**Tweed Sand Plant Expansion (SSD-10398)
Response to Submissions (RTS)**

Attachment A

Detailed advice to DPIE Planning & Assessment regarding the Tweed Sand Plant Expansion (SSD-10398) RTS

Figure 3.3 Local Catchment Map and Flow Paths – Ultimate Case (Phase 11)

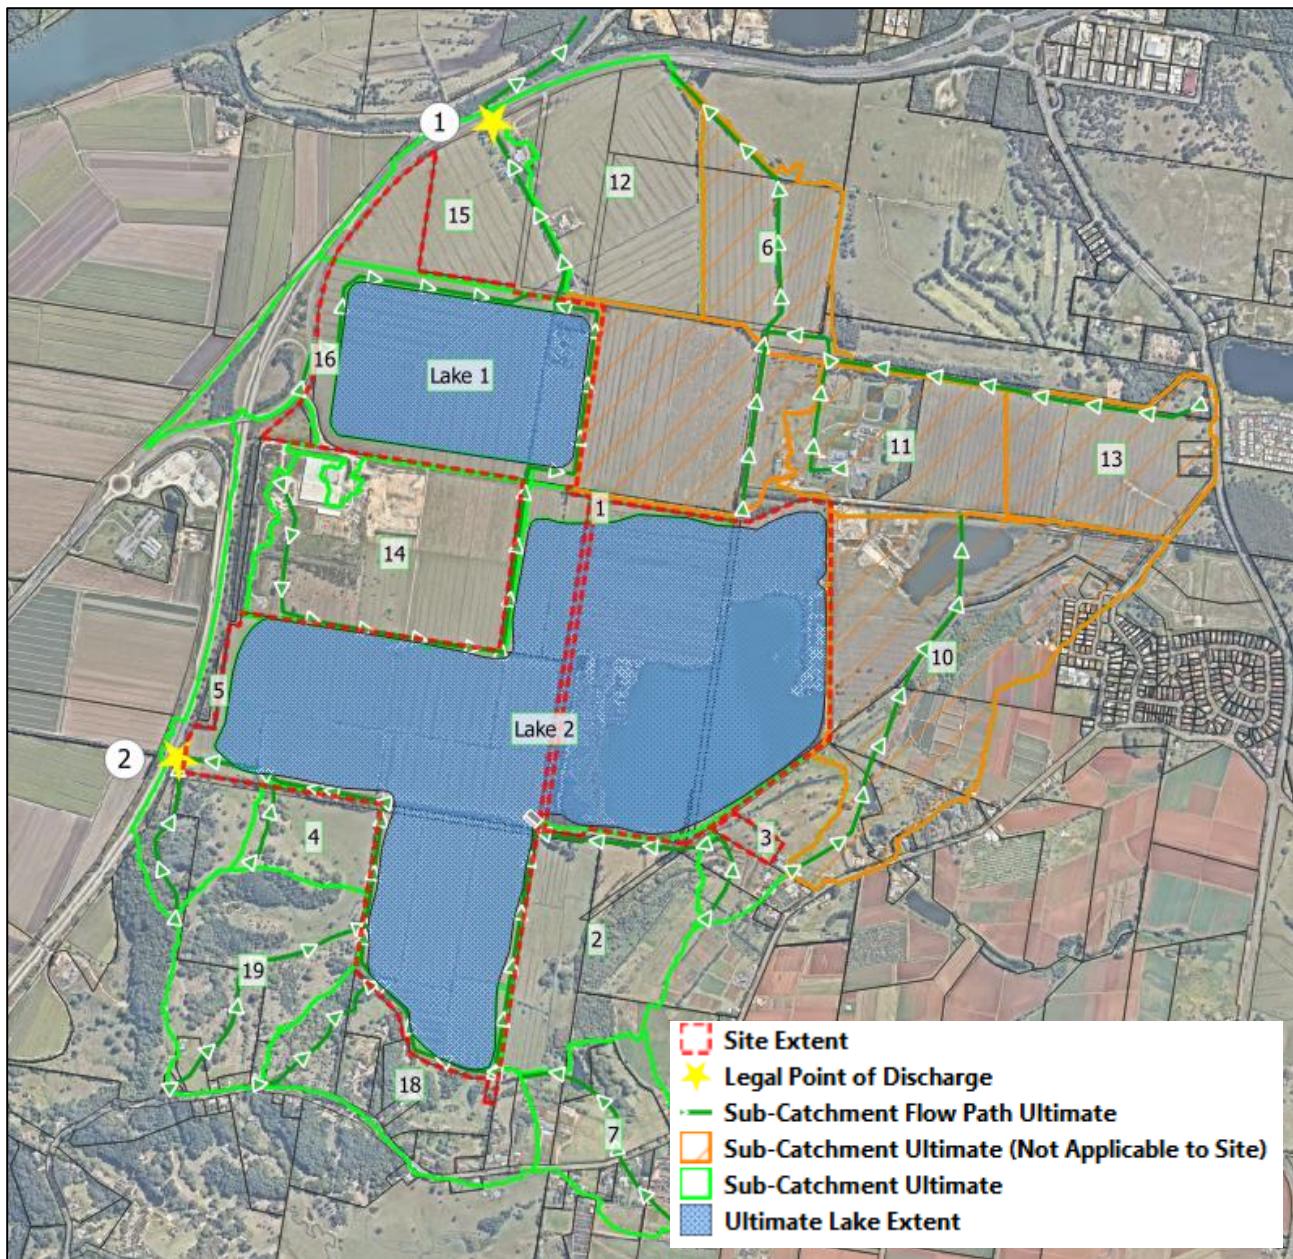
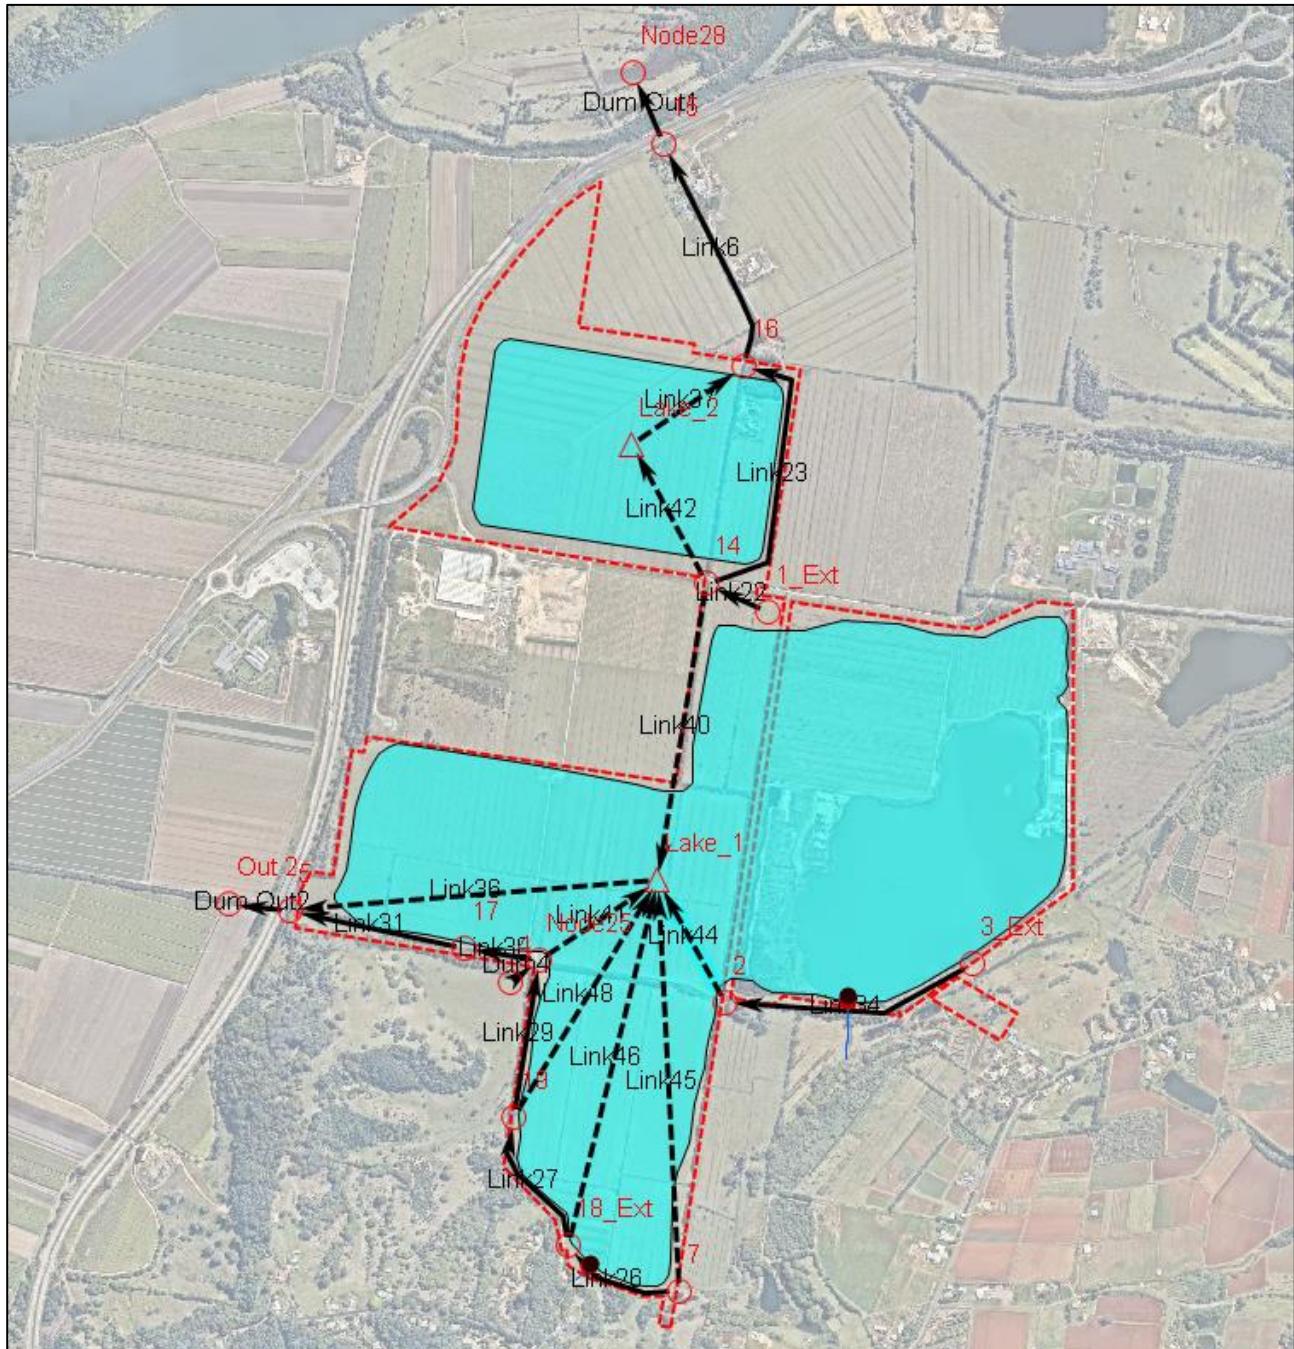
Based on the water management system established by the lakes and associated bunding and channels, the surface water take by the project is the volume of surface water captured in the lakes during each runoff event. This equates to the storage volume between the lake level and the weir outlet level or the maximum height that the lake level reaches during each inflow event. The maximum annual volume captured needs to be quantified and the entitlement requirements confirmed based on consideration of Harvestable Rights.

- quantify the maximum annual volume of surface water take due to runoff from external catchments (catchment runoff or flood flows) for a range of climatic scenarios during the project life and post closure. This needs to be based on the volume of surface water captured and held in the lakes during each runoff event. The maximum annual runoff less the Harvestable Rights for the property will determine the water entitlement requirements. The ability to acquire sufficient entitlement will need to be demonstrated.
- quantify the maximum annual groundwater take due to the project for a range of climatic scenarios during the project life and post closure until equilibrium is reached. This needs to be based on total groundwater inflows and groundwater extraction from the groundwater source. The ability to acquire sufficient entitlement will need to be demonstrated.
